Iglu Redfern

BCA Assessment Report

REPORT 2014/1703 R1.1
November 2014

60-78 Regent St
Redfern
Podium plan
Level 01

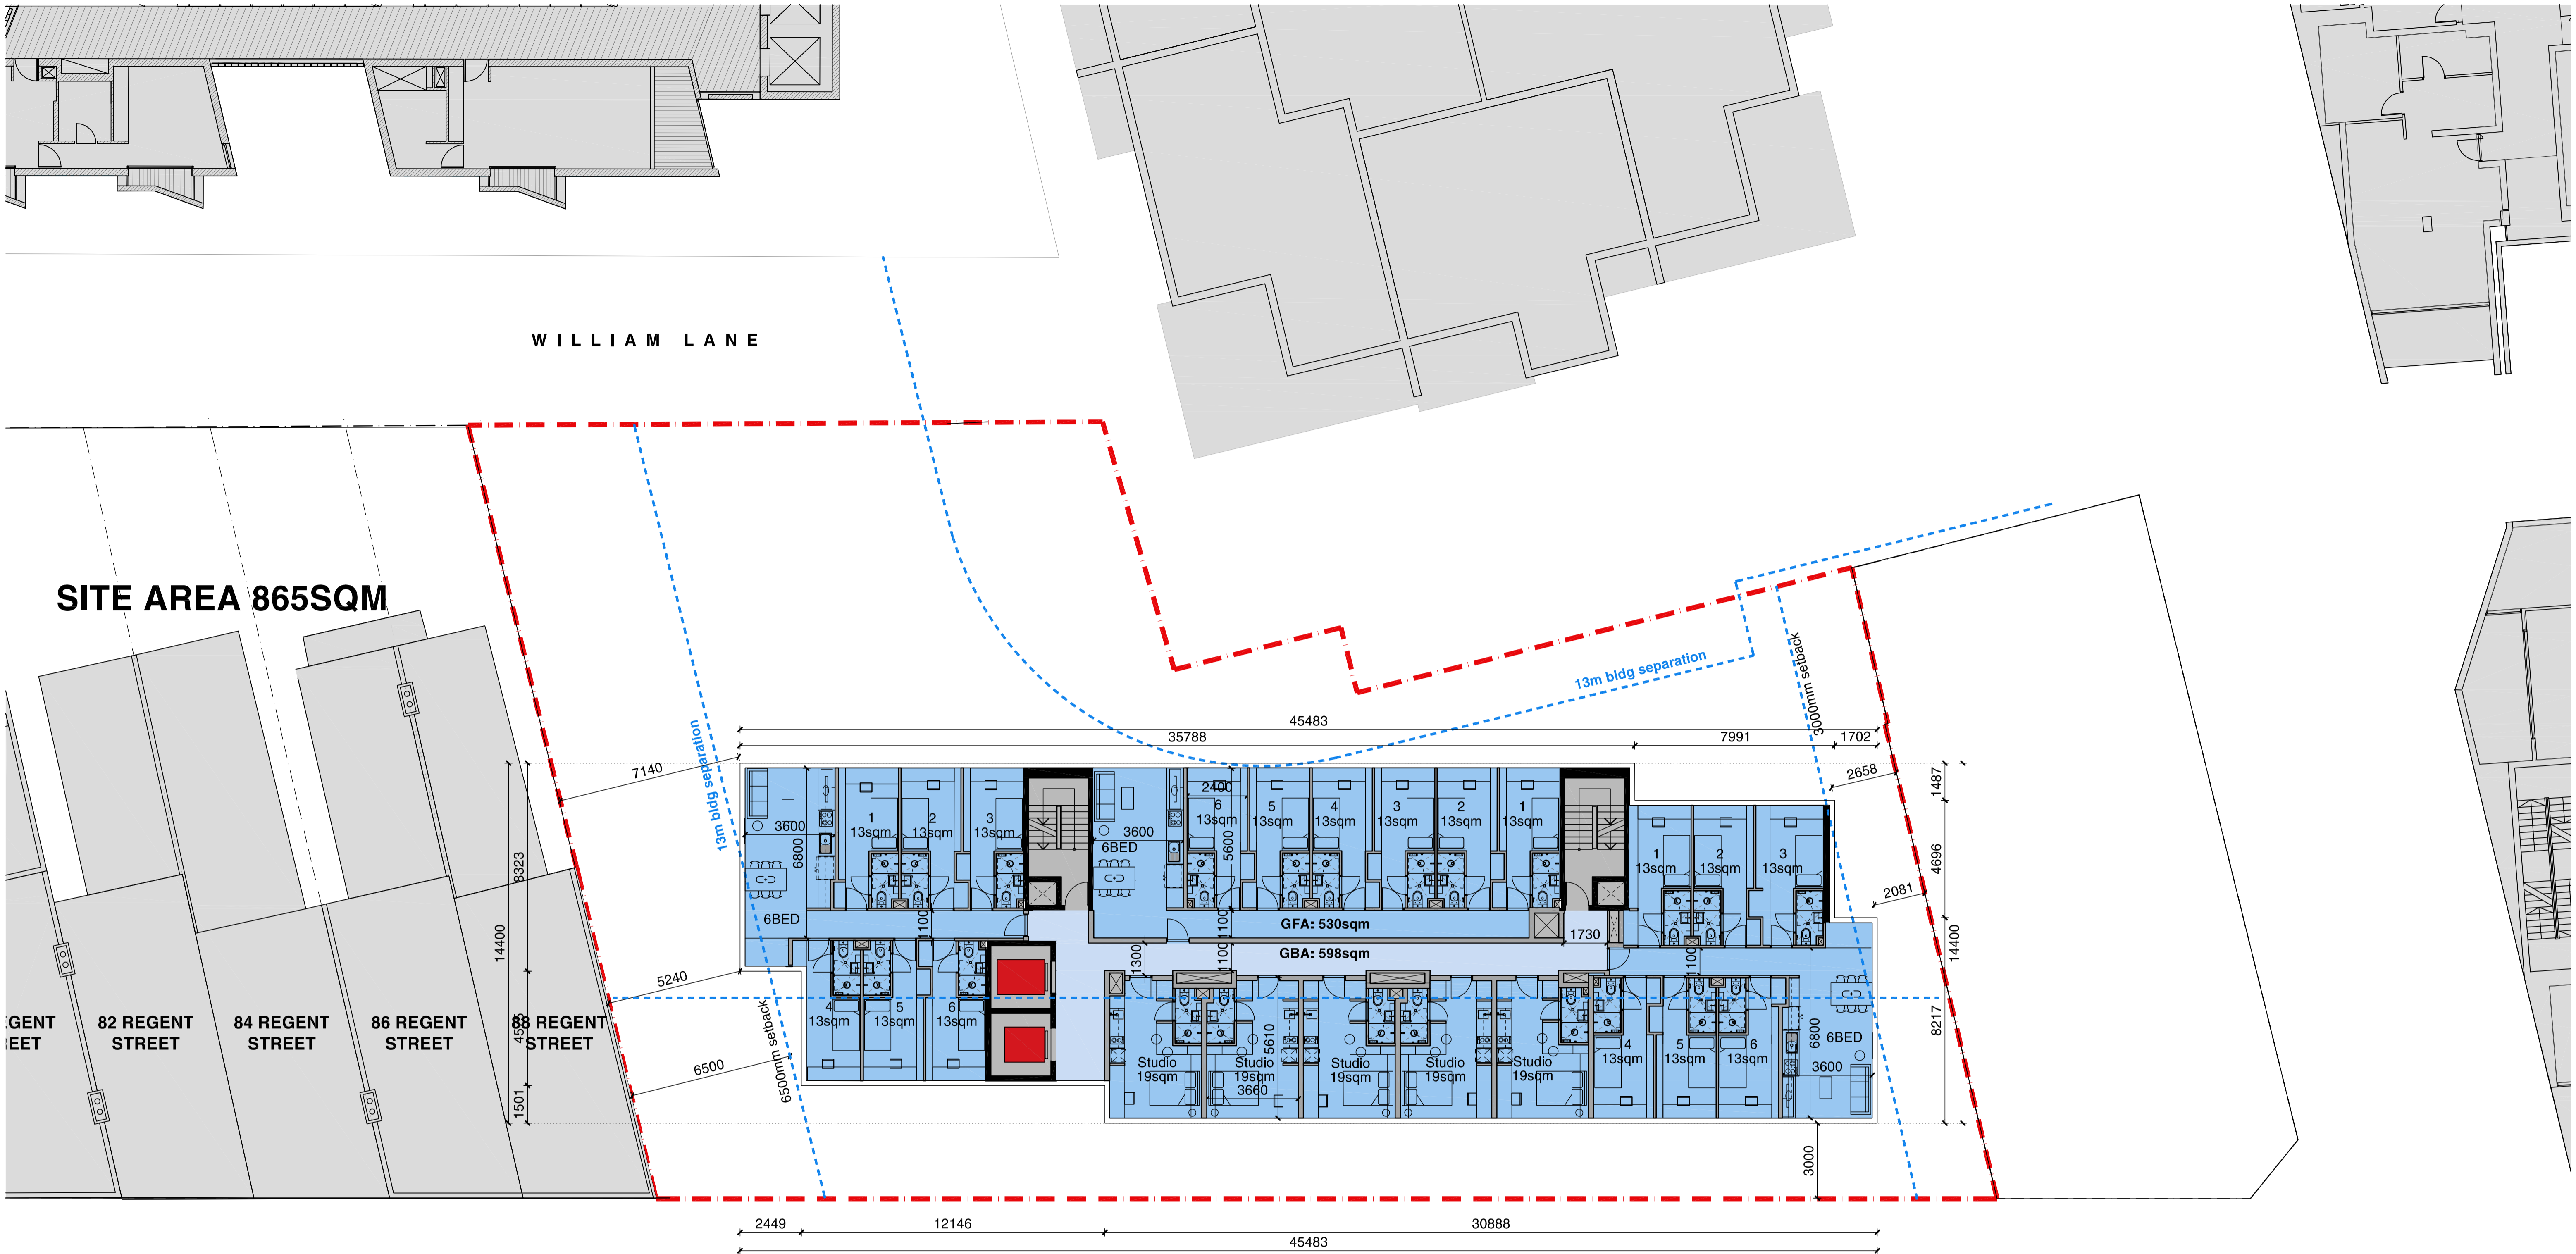
1. Egress from courtyard area on level 1;
2. Operation of latch details and swing direction to security gates in laneways;
3. Details of protection of window openings;
4. Design of key essential services compliance eg fire hydrant, sprinkler systems;
5. Design of fire control room requirements;
6. Provisions of floor wastes to bathroom and laundries;
7. Provision of ambulant sanitary facilities for male and females.

3.	Reduced FRL's – Public corridor level 01	C1.1, Spec C1.1	Level 01 podium will not have internal walls bounding the public corridors achieve an FRL of --/60/60. The public corridor is from the cluster to both fire stair exits	CP1 & CP2

6.	Bounding construction doorways	C3.11	Level 01 podium level will have doorways from rooms not within an SOU that open into the public corridor that are not self-closing -/60/30 fire doors.	CP2

Item	Non-Compliance	DTS Clause	Description	Performance Requirement	Comments
10.	Exit travel distances (Non SOU's)	D1.4	Exit travel distances from point not within an SOU to an exit or point of choice between exit exceeds 20m as follows: <ul style="list-style-type: none"> Up to 31m from kitchen within cluster on Level 01. Up to 35m from Store room on mezzanine level 	DP4 & EP2.2	Triggers Fire & Rescue NSW referral
